Re: Performance Plus

6900 Huseman Pl SW Grading and Drainage

Engineers Stamp Date 12/29/2016 (M10D016G)

Re: Performance Plus Additions,
6900 Huseman Place SW (Lot 15), Drainage Plan
Engineer's Stamp dated 10-09-08 (M-10/D016G)

GRADING & DRAINAGE PLAN

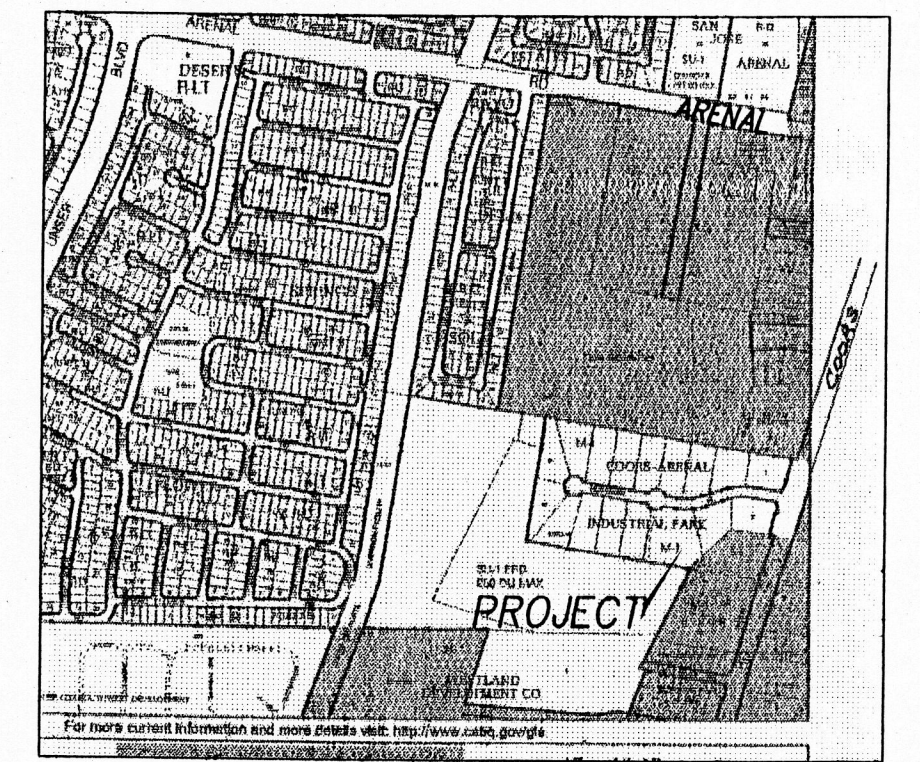
1. Provide the water surface elevation for the proposed expanded retention pond.

2. Please remove the riprap (6'x1') spillway.

3. Extend the earth mound, elevation contour 4976, around the back of proposed retention pond to the northeast corner of existing chain link fence (proximity).
